BERRYS BAY STUDIO

Objection: SSD-93020230

40 – 48 Redan St, MOSMAN

On behalf of Neighbouring Residents

Site Analysis
Site Plan

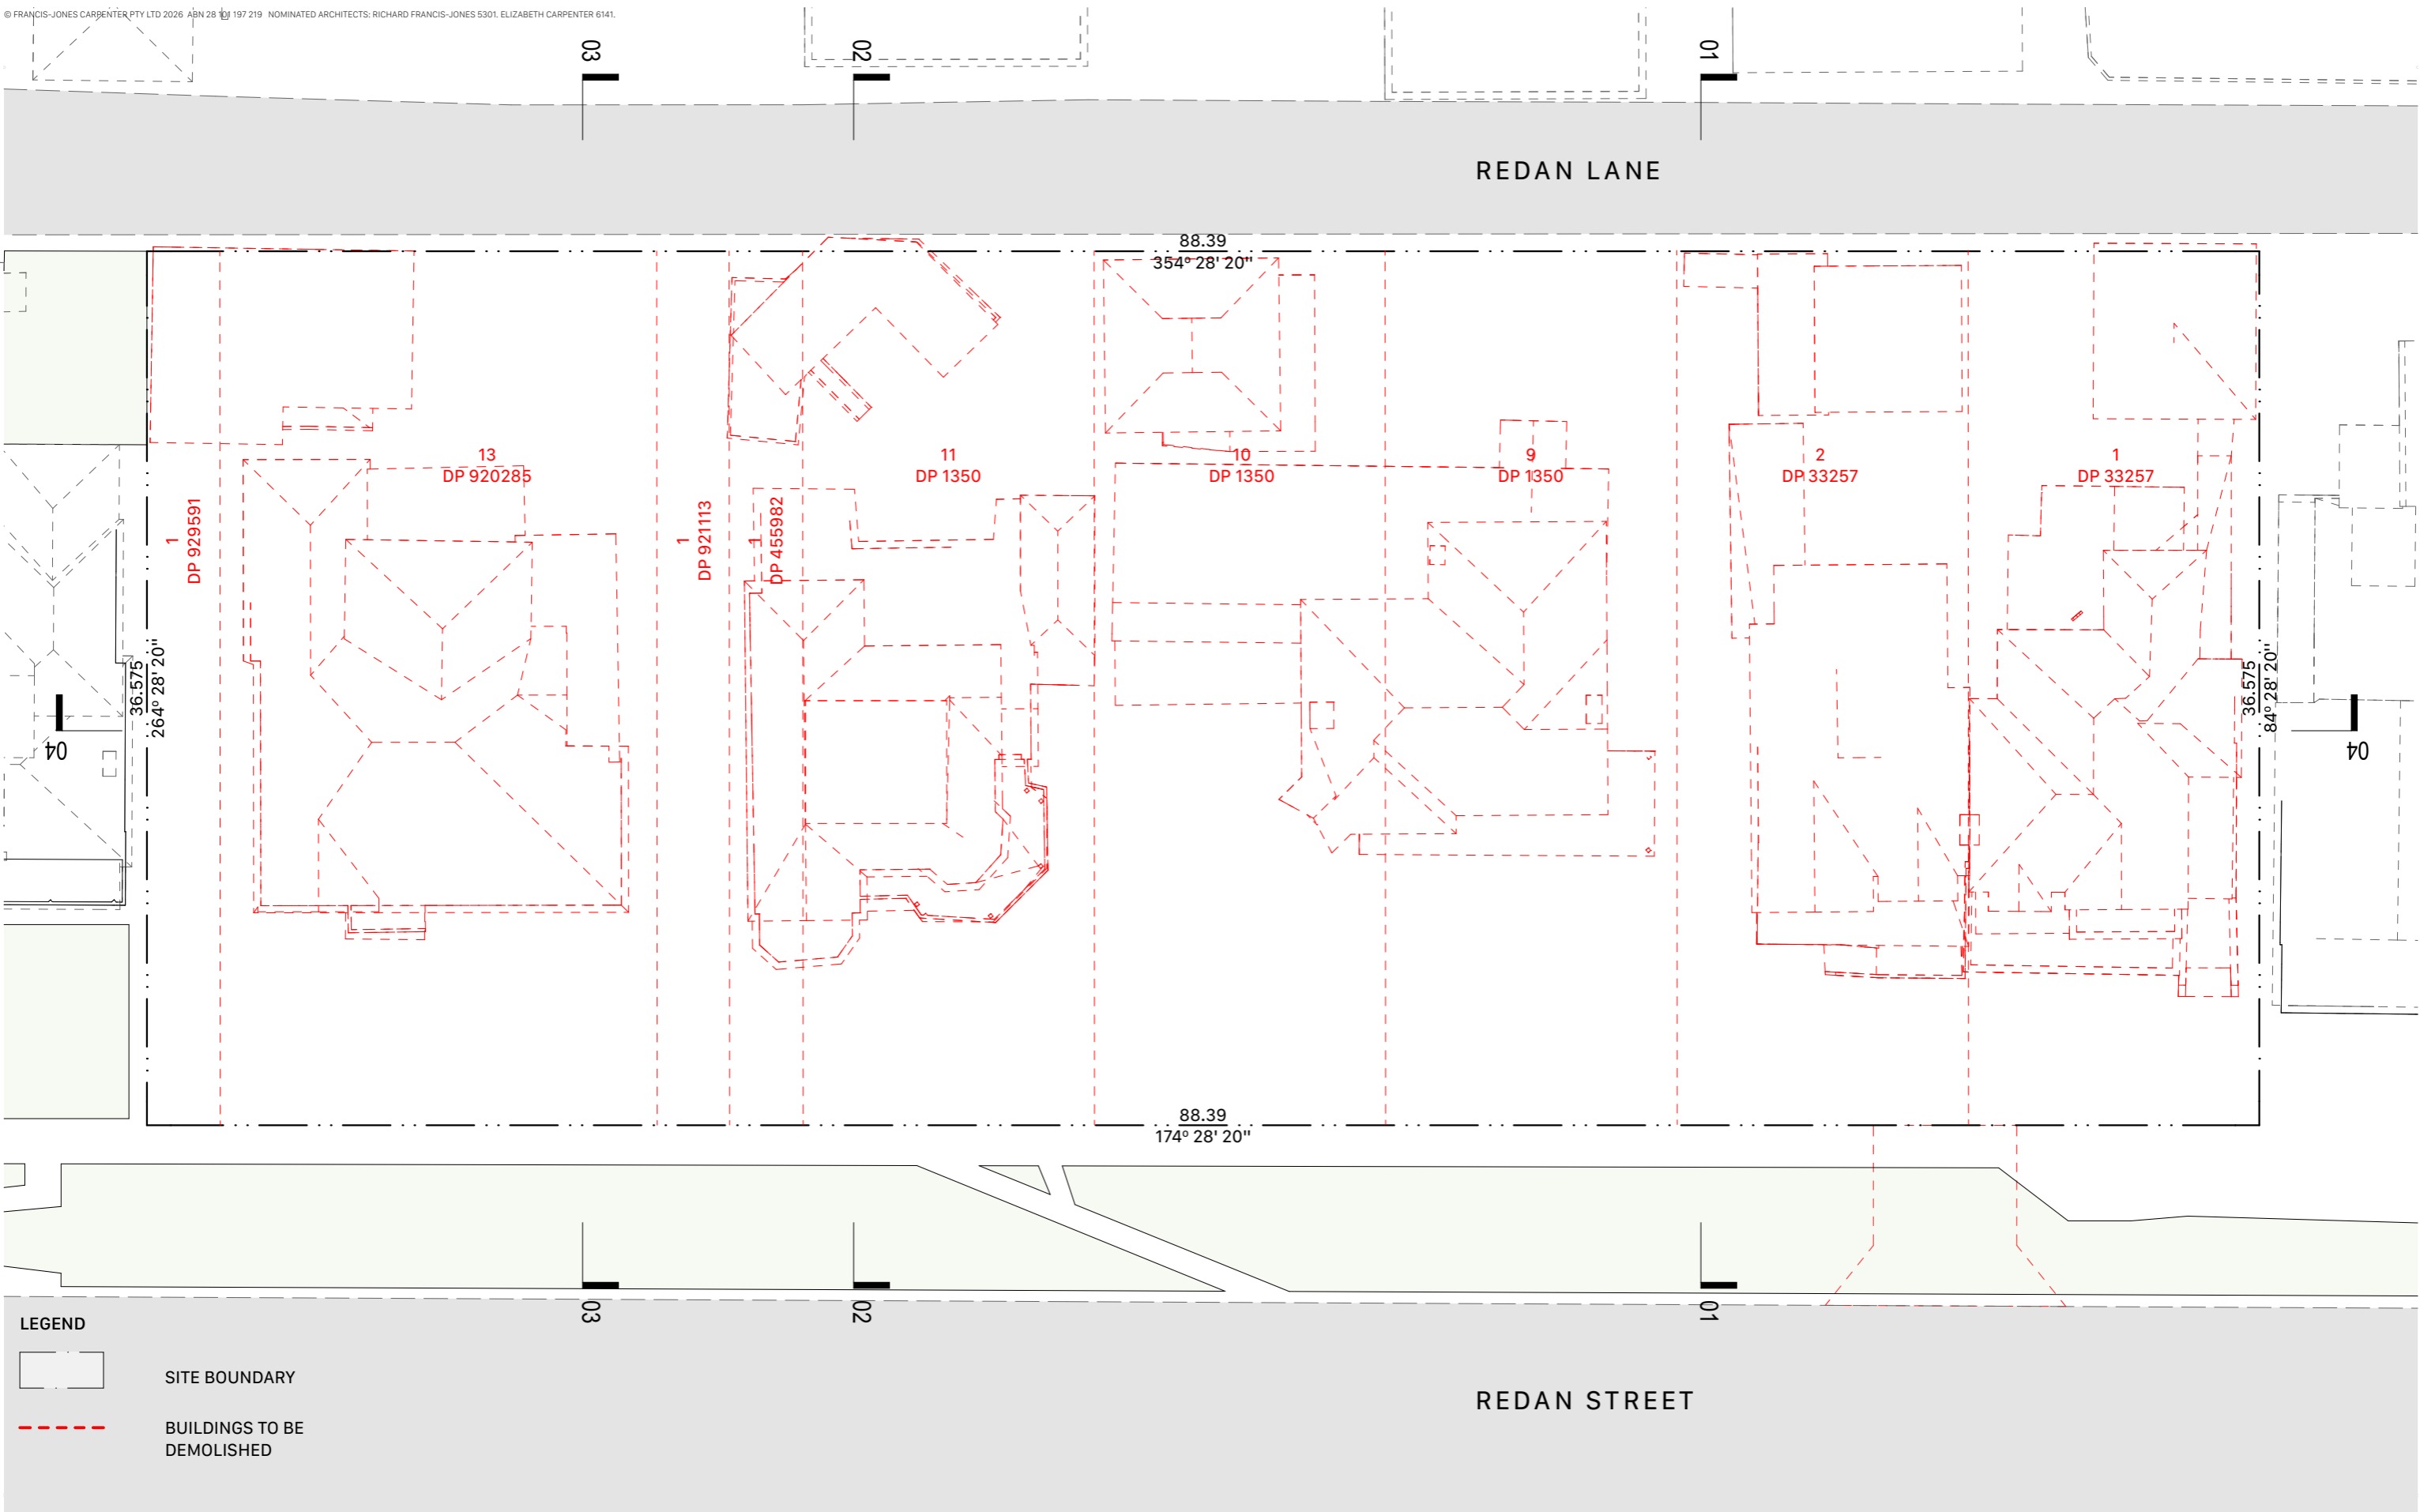
Figure 5 - Site Analysis – fails to recognise views from neighbouring properties

40-48 Redan Street, Mosman 40-48 Redan Street Mosman NSW 2088	Section 1 EW North Sections	Rev	Date	Description	By	Chk	Scale	Code	Sheet	Rev	0 2.5 5 10m	
		B	27/2/2026	SSD Submission - Lodgment	IS	1:250 @ A3	TPRS	4000	B

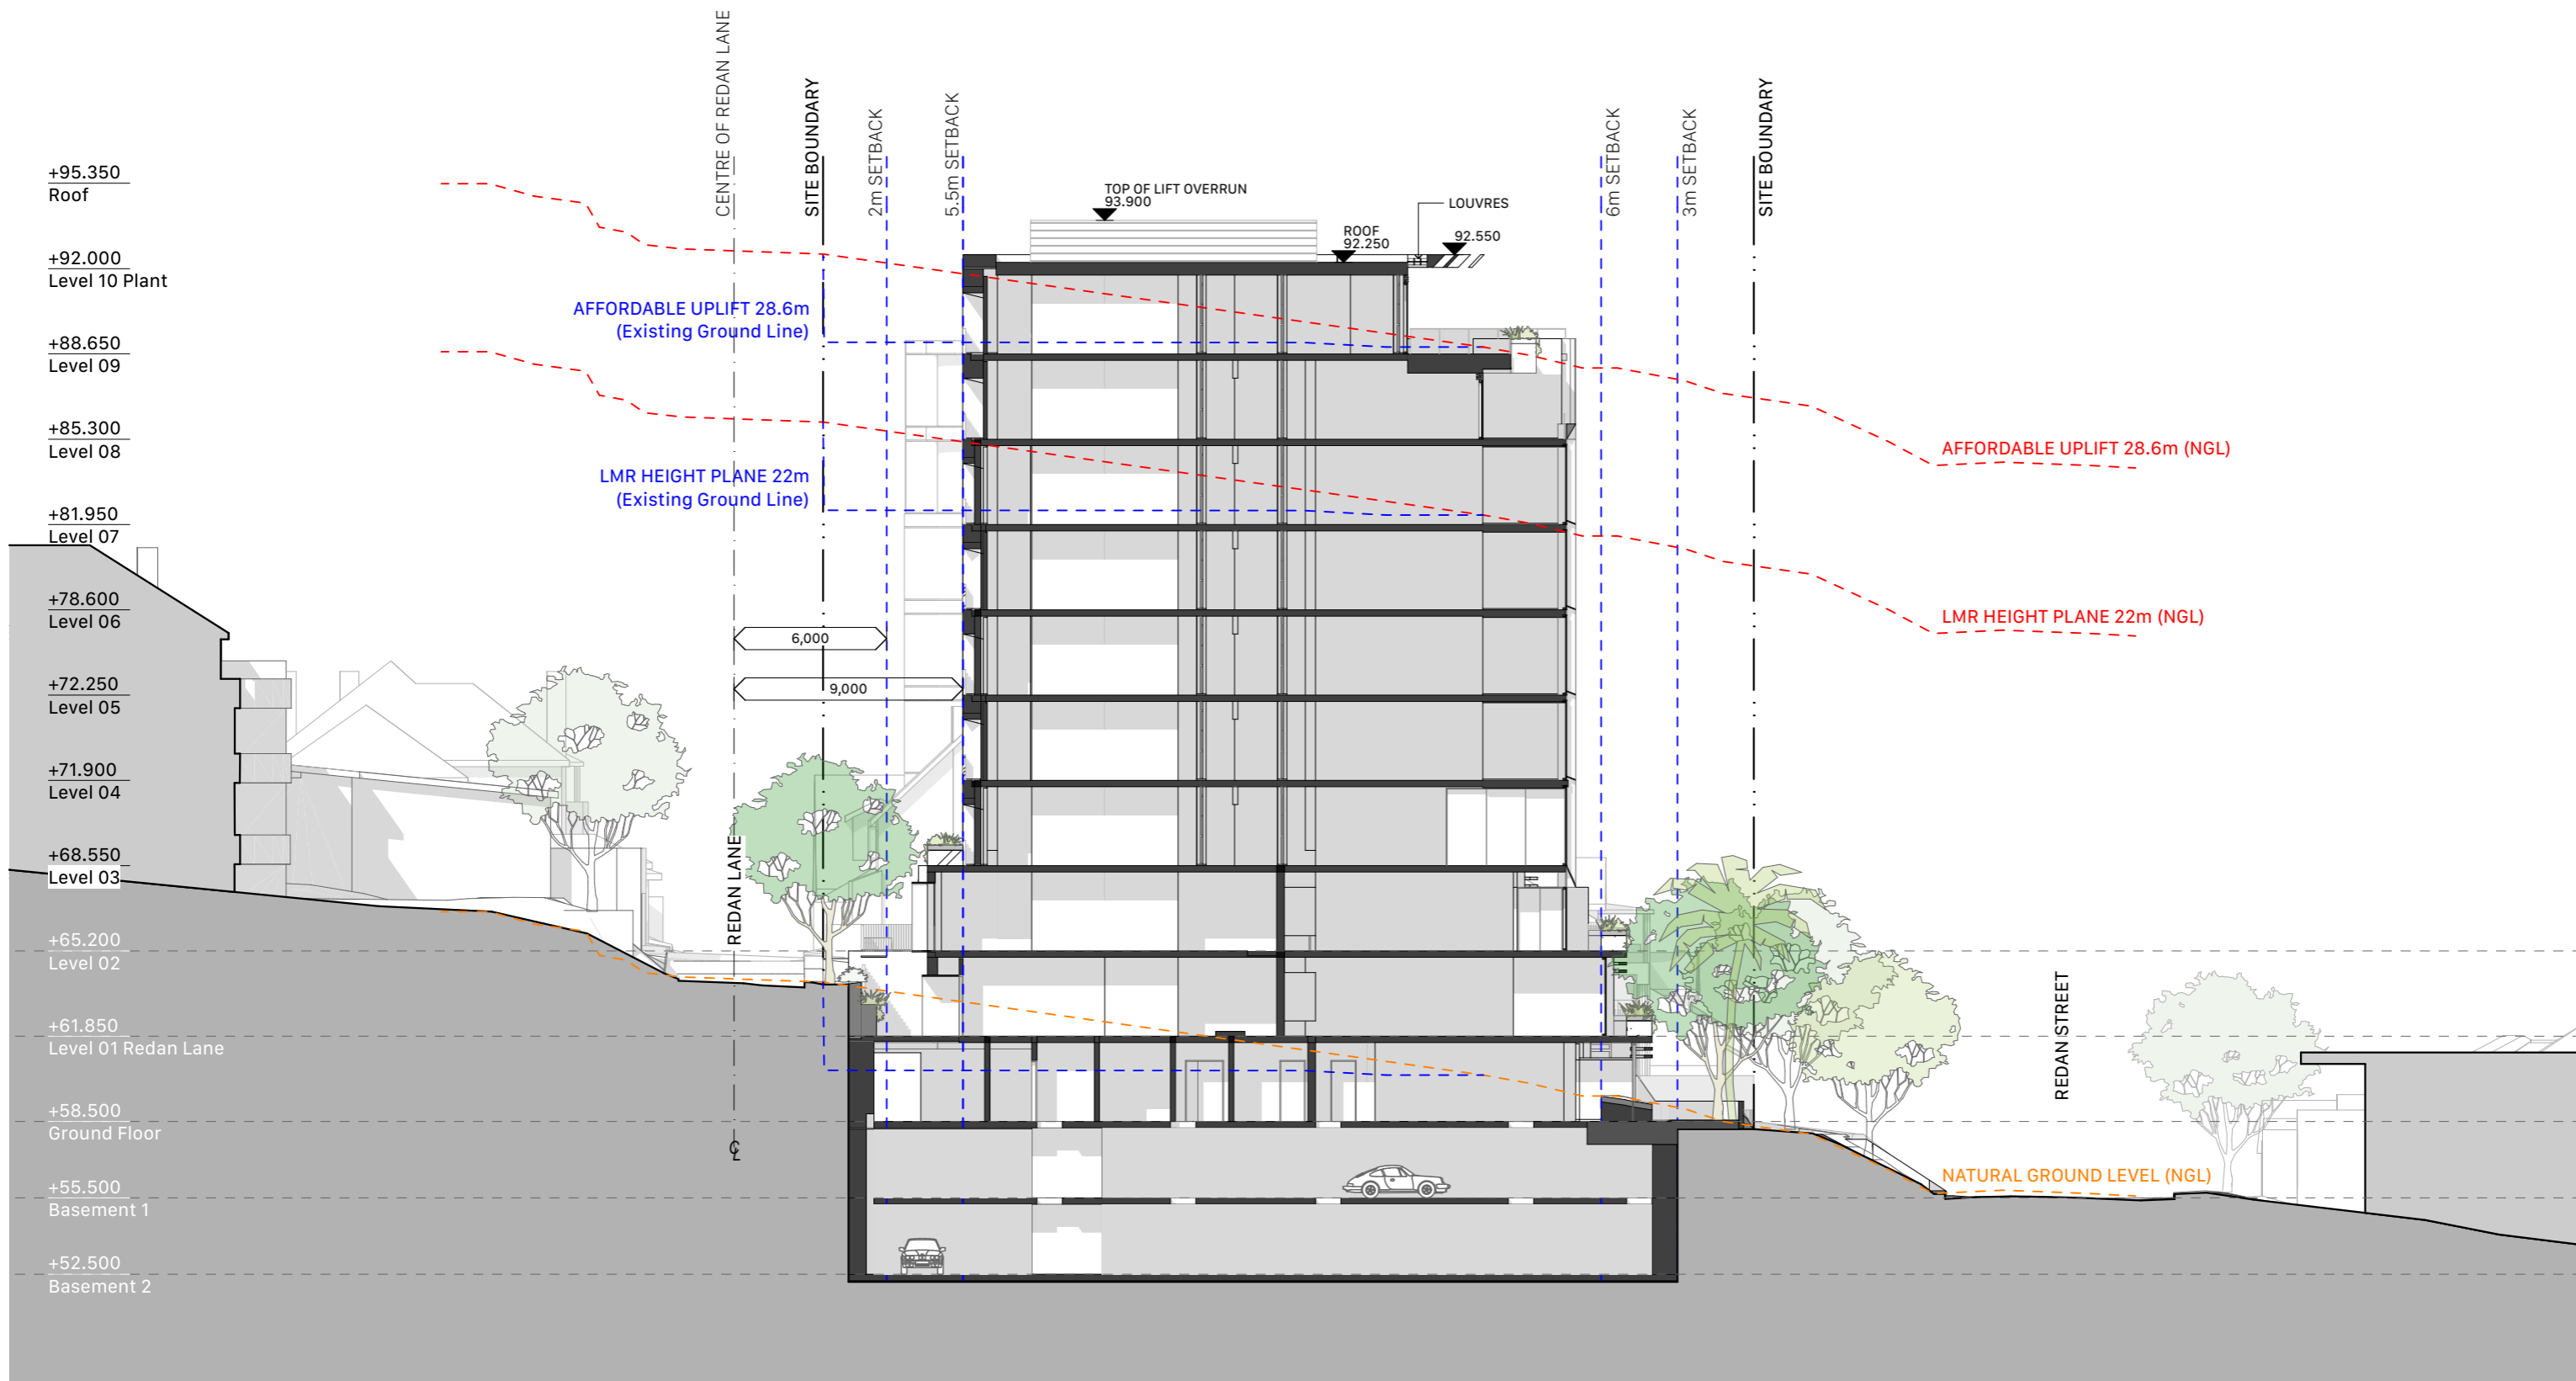
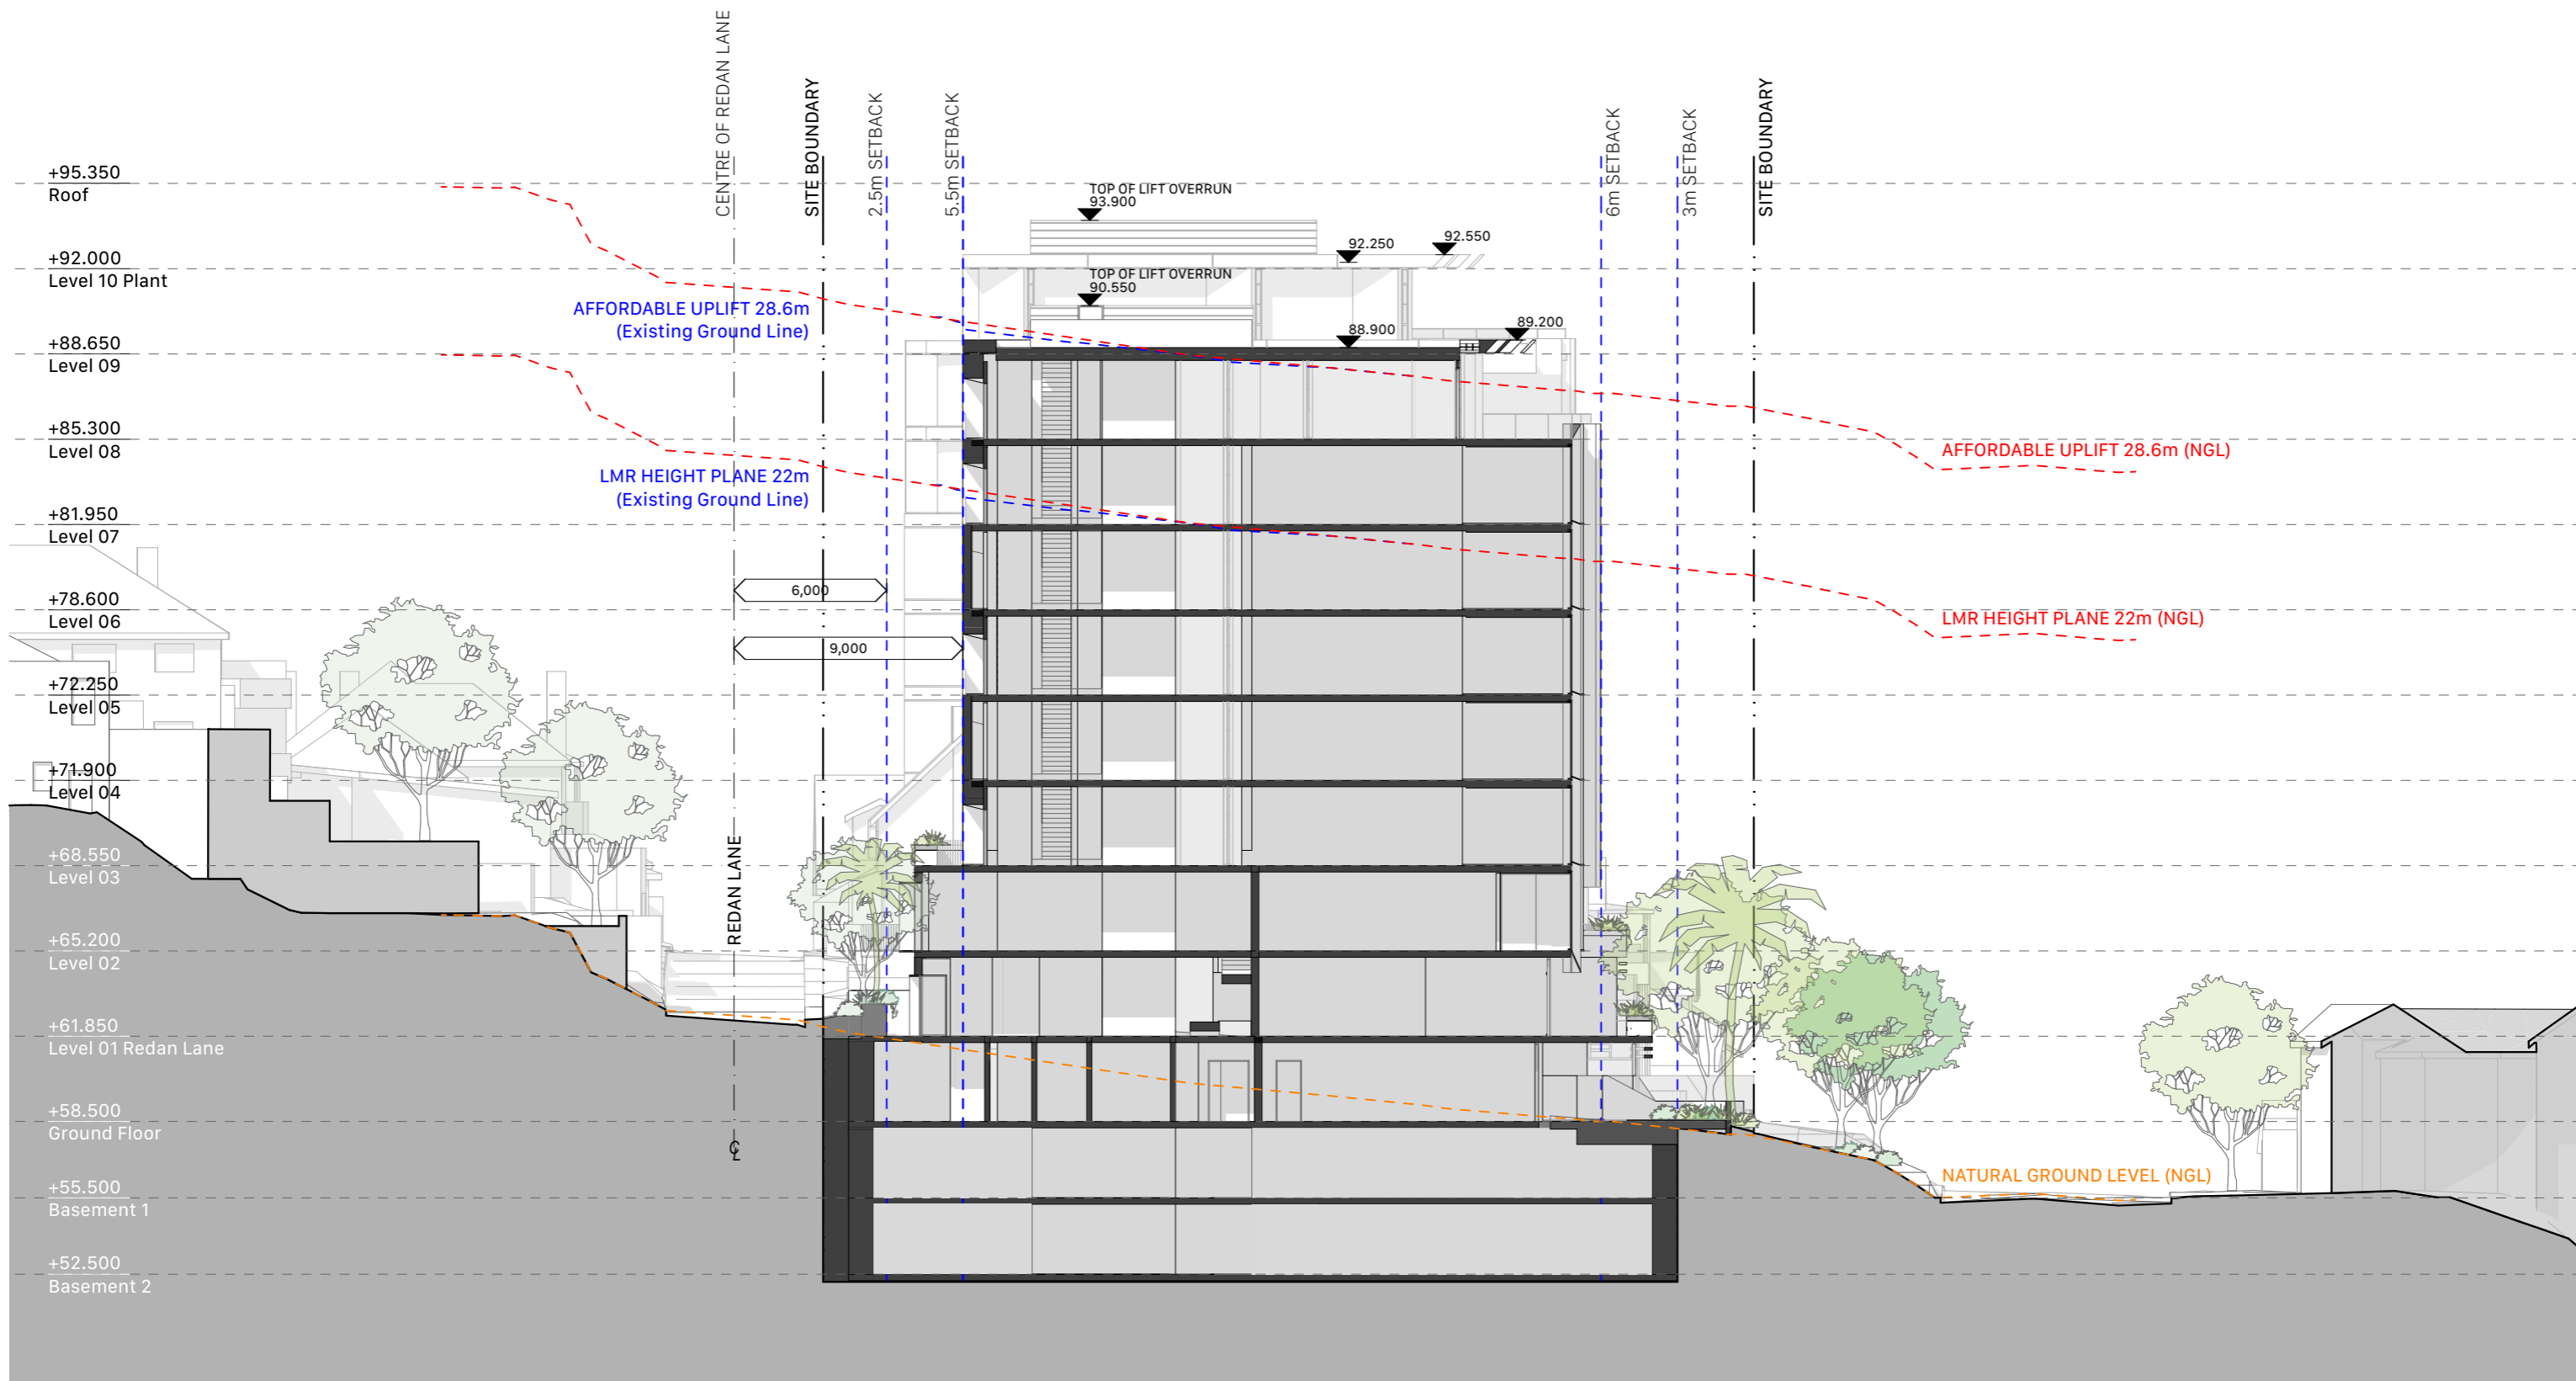
Even with the application of the Low to Mid-Rise (LMR) provisions and a 30% affordable housing bonus—which brings the maximum permissible building height to 22.75m—the proposal significantly exceeds this limit. The northern portion of the building reaches an overall height of 33.4m to the top of the lift overrun and 32.2m to the parapet. This represents a variation of up to 10.65m, exceeding the absolute maximum allowable height by 46.8%. The central portion also breaches the control, reaching 30.2m (a 32.7% exceedance).

The site is zoned R3 Medium Density Residential with a mapped maximum building height of 8.5m and a corresponding wall height control of 7.2m under the Mosman LEP 2012. The proposed development completely disregards this local standard. The proposed wall heights reach 32.2m in the northern portion, 30.4m in the central portion, and 23.5m in the southern portion. These represent extreme departures of 25m, 23.2m, and 16.3m respectively from the 7.2m control.
